Council Reference: DA19/0683 & DA18/0681.01 LN84310
Your Reference: SSD-10353

TSC COMMENTS MOD 2 State Significant Development SSD 9575 (Council Reference DA18/0685.01) - Concept Application, & DA19/0683 Stage 2 for the construction works for the new Tweed Valley Hospital (NSW Planning & Environment App No. SSD 10353) at Lot 11 DP 1246853; No. 771 Cudgen Road CUDGEN

Diagram 4.1: Sewer Connection Point

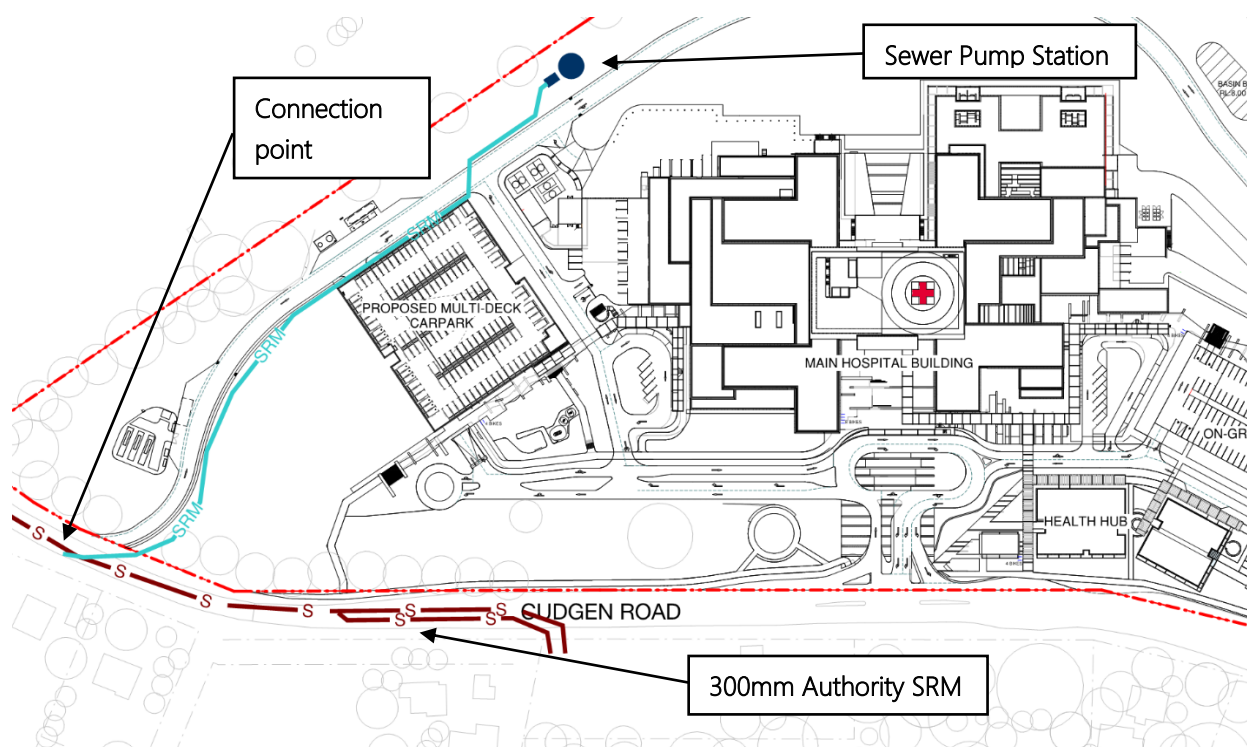
8. The Plans and Drawings in Appendix B (Part 5) shall update the connection shown to the Council sewer rising main to include a boundary kit at the Hospital property boundary and a connection to Council standards within the road reserve.
